From: [Beverly Kluth](#)
To: [CDS User](#); [Jamey Ayling](#)
Cc: [Jeff Kluth](#)
Subject: Fwd: Fowler Creek Guest Ranch (CU 23-00003) - corrections
Date: Monday, October 2, 2023 2:14:43 PM

From: Beverly Kluth <mrsbeldar@icloud.com>
Subject: **Fowler Creek Guest Ranch (CU 23-00003).**
Date: October 2, 2023 at 1:22:19 PM PDT
To: cds@co.kittitas.wa.us, Jamey.ayling@co.kittitas.wa.us
Cc: Jeff Kluth <beldar20001@icloud.com>

Exhibit 1 - Fowler Creek Narrative

FOWLER CREEK GUEST RANCH
EXHIBIT 12
EMERGENCY INGRESS AND EGRESS PLAN

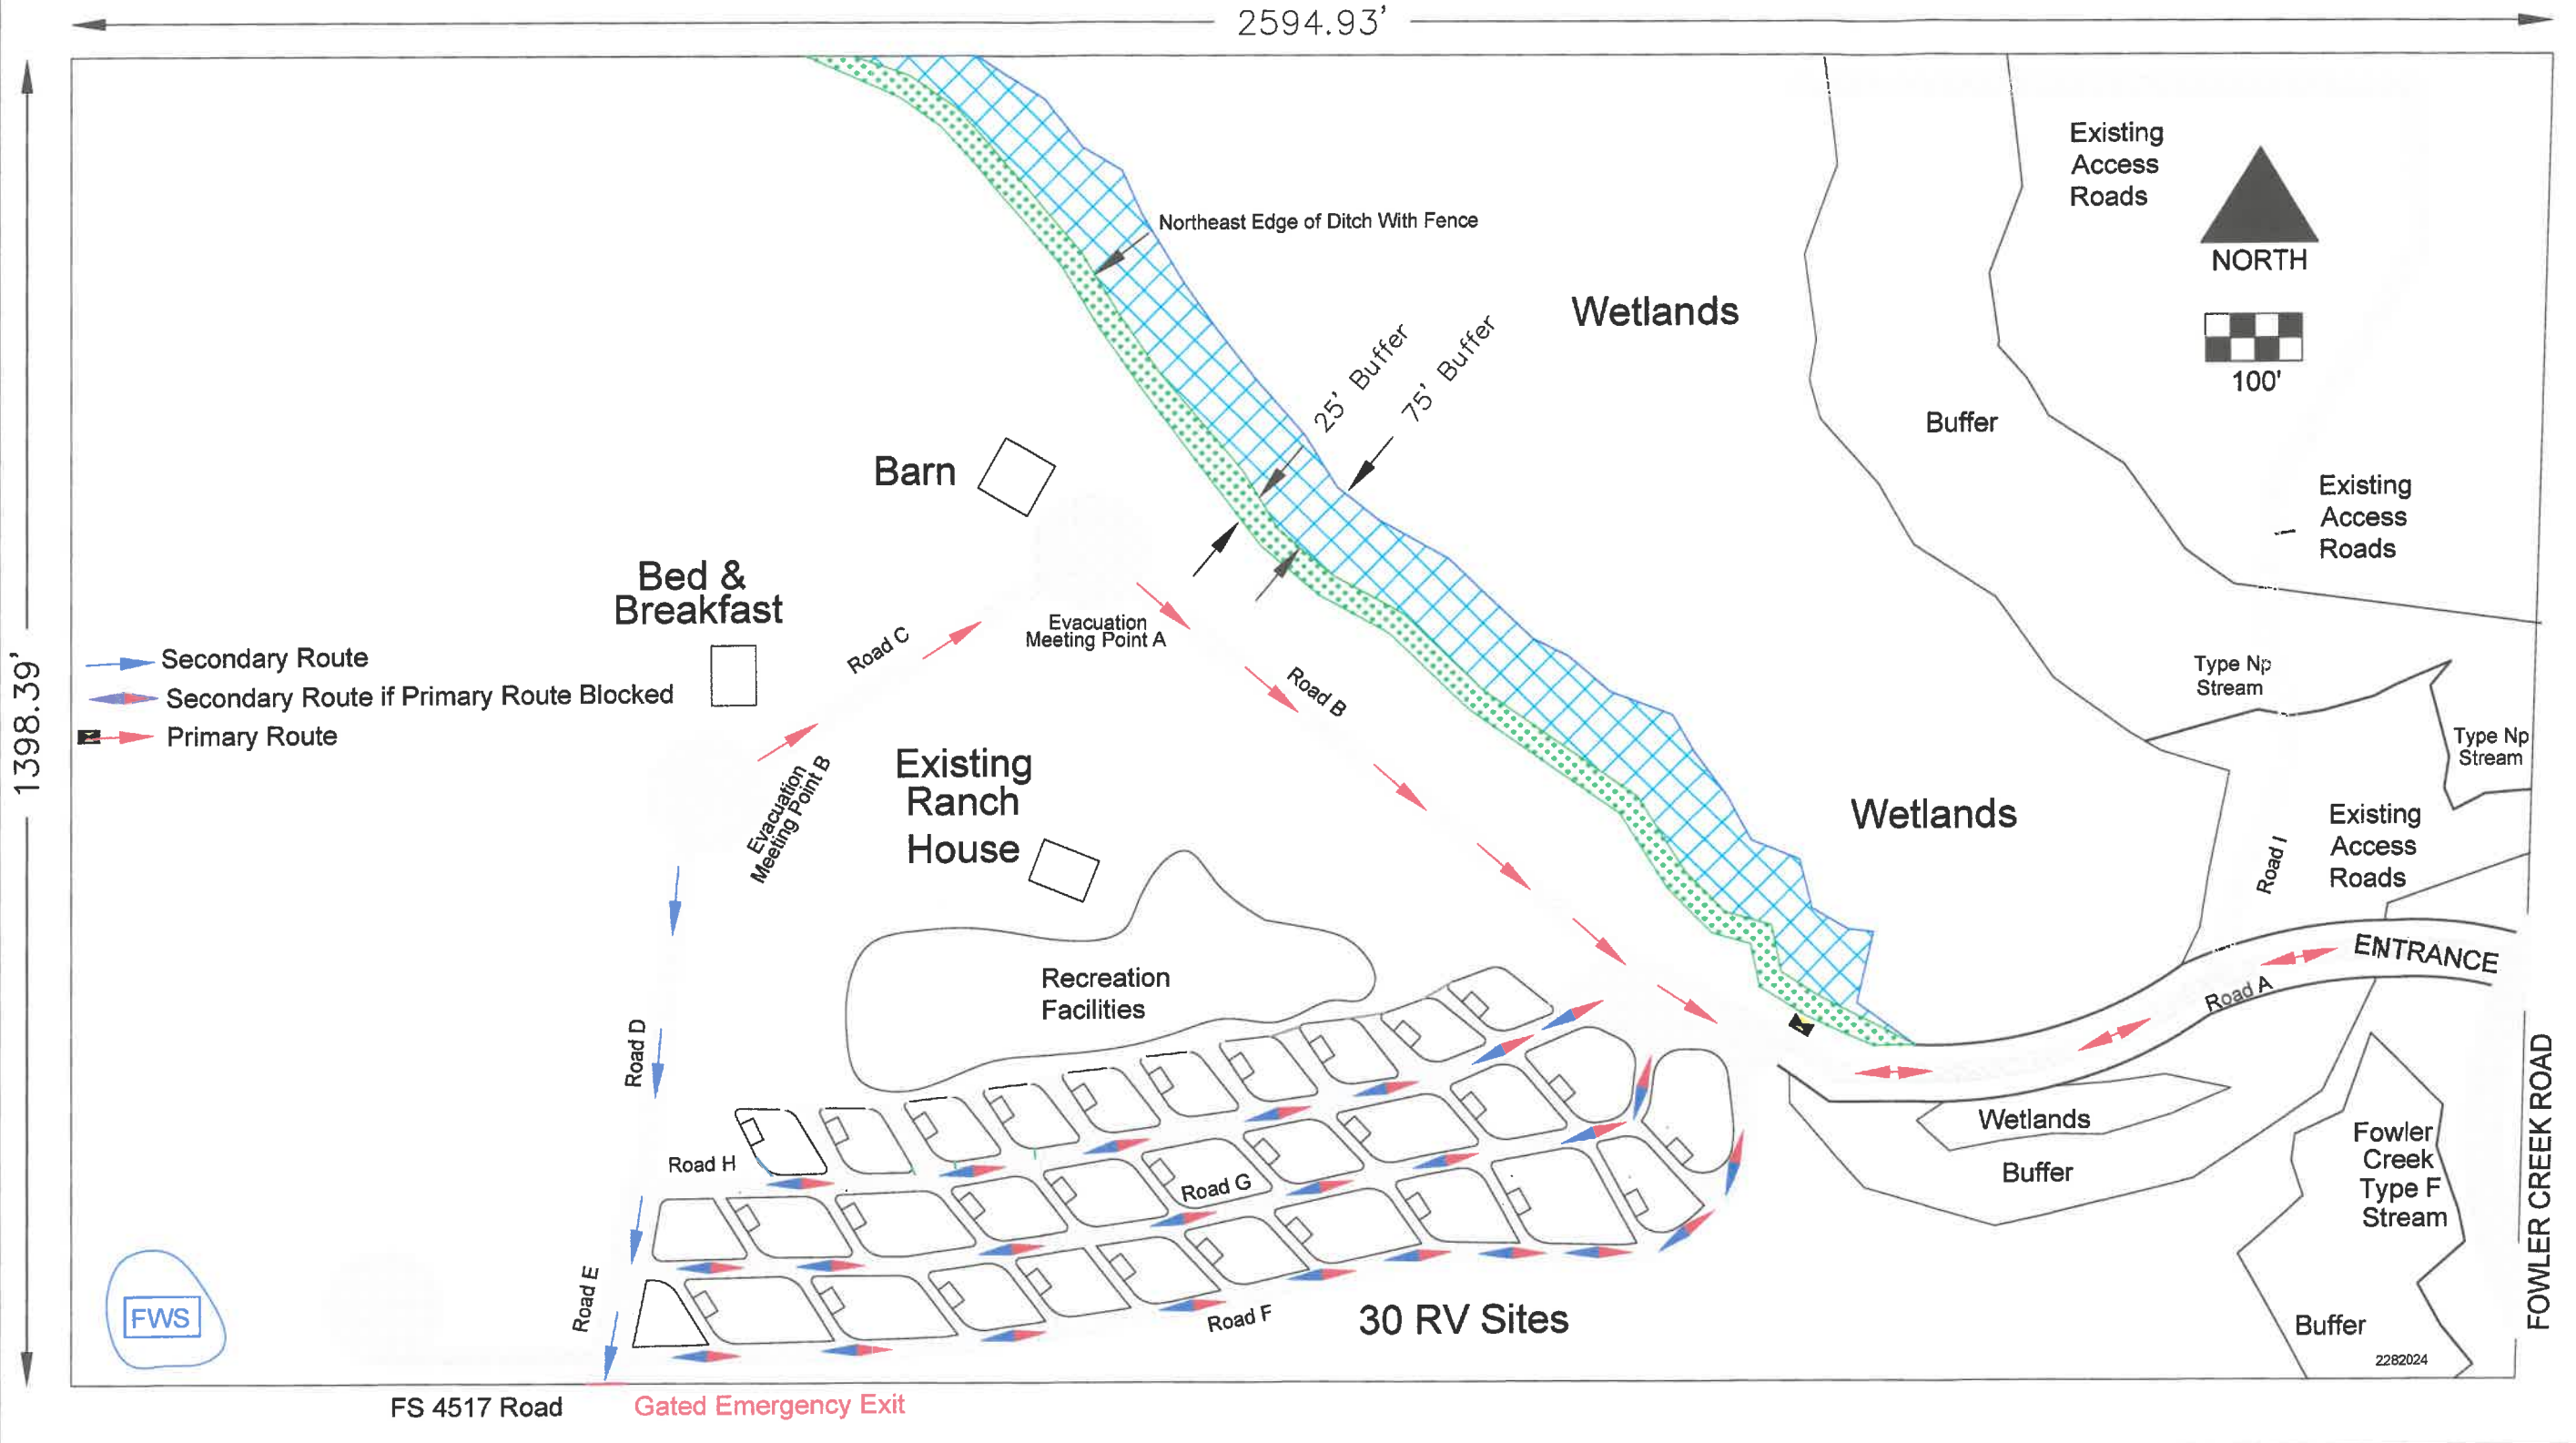
Exhibit 12, Fowler Creek Guest Ranch Traffic

I am not seeing anything that addresses the existing problem of traffic congestion on West Side Road over summer weekends. This was written using old information on traffic counts and counts that were done in the month of September, which is when traffic is at it's minimum around these parts. West Side Road traffic problems will be more compounded if this proposal is approved. The traffic counts referenced in this exhibit are old and were performed in September. This information is unreliable and relatively useless in terms of impact.

What authority performed this write-up and analysis of the traffic measurement using the Trip General Manual which is what Exhibit 12 states was used to determine traffic? The applicant? If so, is he an accredited transportation engineer? I would expect that a Traffic Impact Study be prepared by an accredited transportation engineer before Kittitas County would take any of the information in Exhibit 12 as factual and reliable.

Exhibit 12, section A, (iii) states that the only truck traffic that will occur is during the build of this resort. That is just wildly untrue. Large RVs and trucks pulling RVs, trucks pulling trailers with snowmobiles and ATVs will continually be going in and out all the time.

Exhibit 12 also references traffic counts at Westside Road and Zrebic Road from September 2020, which should not be considered as it was during the pandemic, was done in September when traffic is lower because school starts and also is old information.

EXHIBIT 16 - SITE PLAN - FOWLER CREEK GUEST RANCH

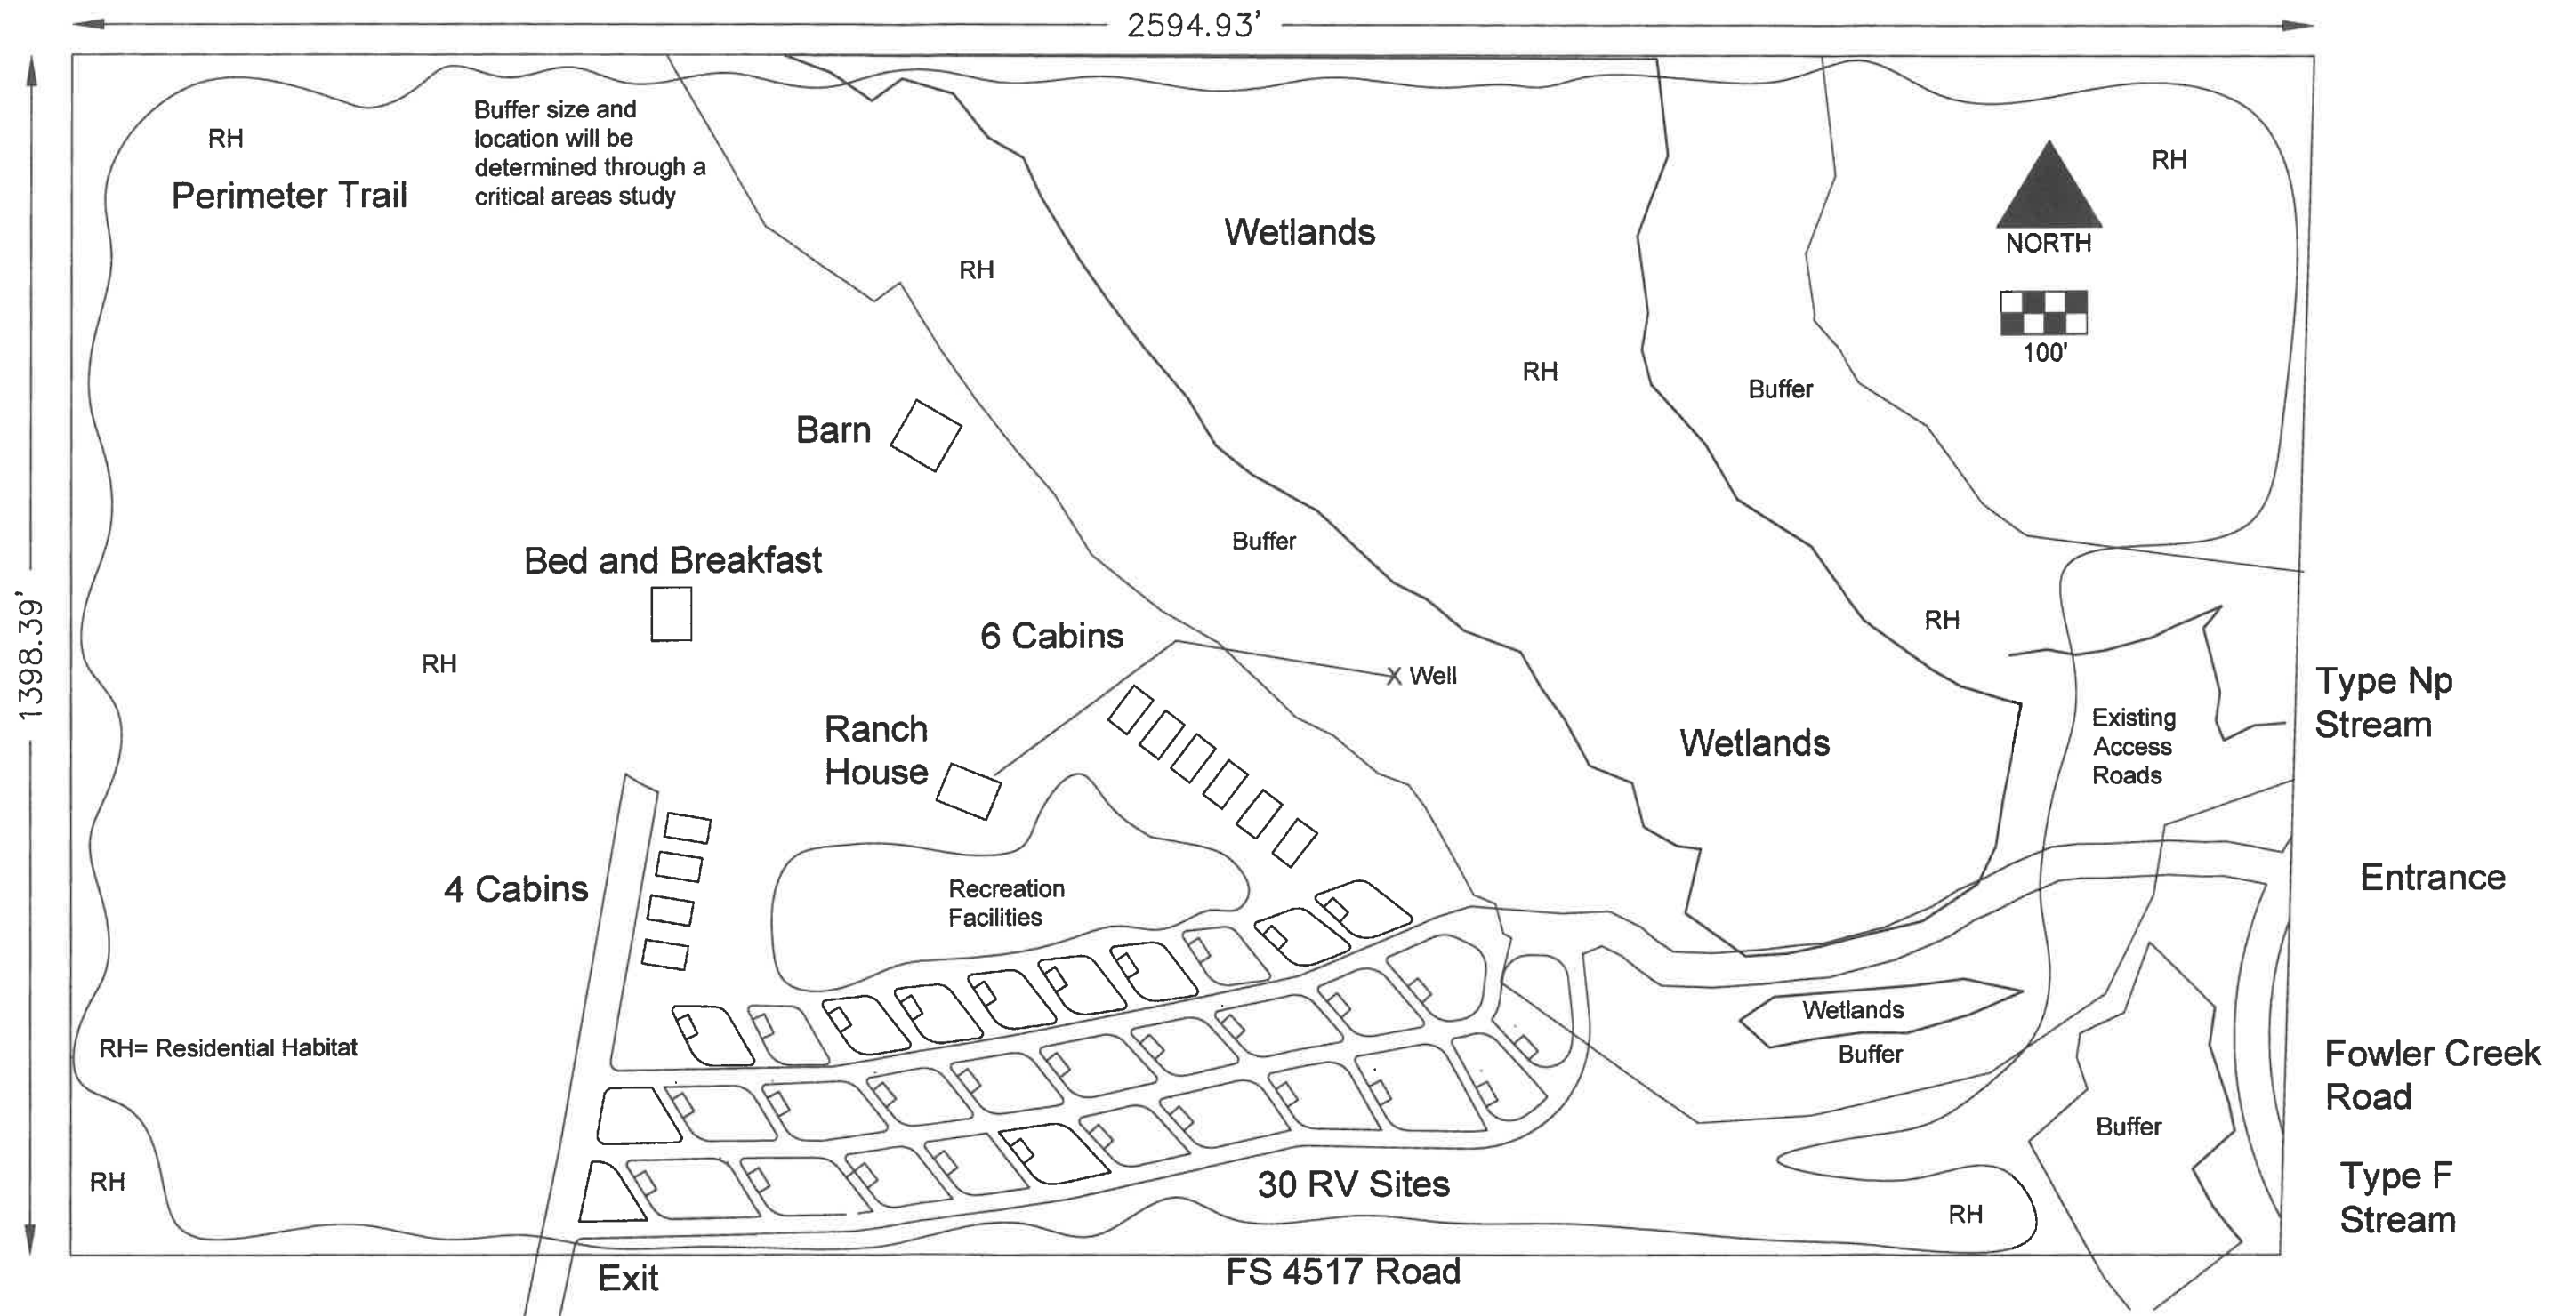
This exhibit is missing much information. It doesn't even list how many of these residential habits (RHs) there will be, it's necessary to review Exhibit 16, Site Plan where I count 8 of them, one is smack dab in the middle of what is designated as Wetlands on the map. Will water or toilet facilities be available for these and if so where? How are the sewage concerns addressed in an ecologically safe manner since these habitats will be situated closer to wild life areas and wetlands? Will there be lights at each habitat? Will they be heated and if so, how? Will these be open year round? Was vehicle traffic by these tourists staying in these habitations added to the numbers in Exhibit 12? This is so very unclear and unacceptable. I'd really like to know what the Department of Fish and Wildlife and the Department of Ecology would have to say about this exhibit, are they aware of this plan?

This exhibit doesn't provide enough detail about the entrances/exits to this resort. In the document titled 'SURROUNDING PROPERTY REVIEW there is reference to an east entrance, west entrance, and a north activities location. There is no indication on the site plan for an east entrance, west entrance or a north activities notation. It's not clear where entrances and exits will exist.
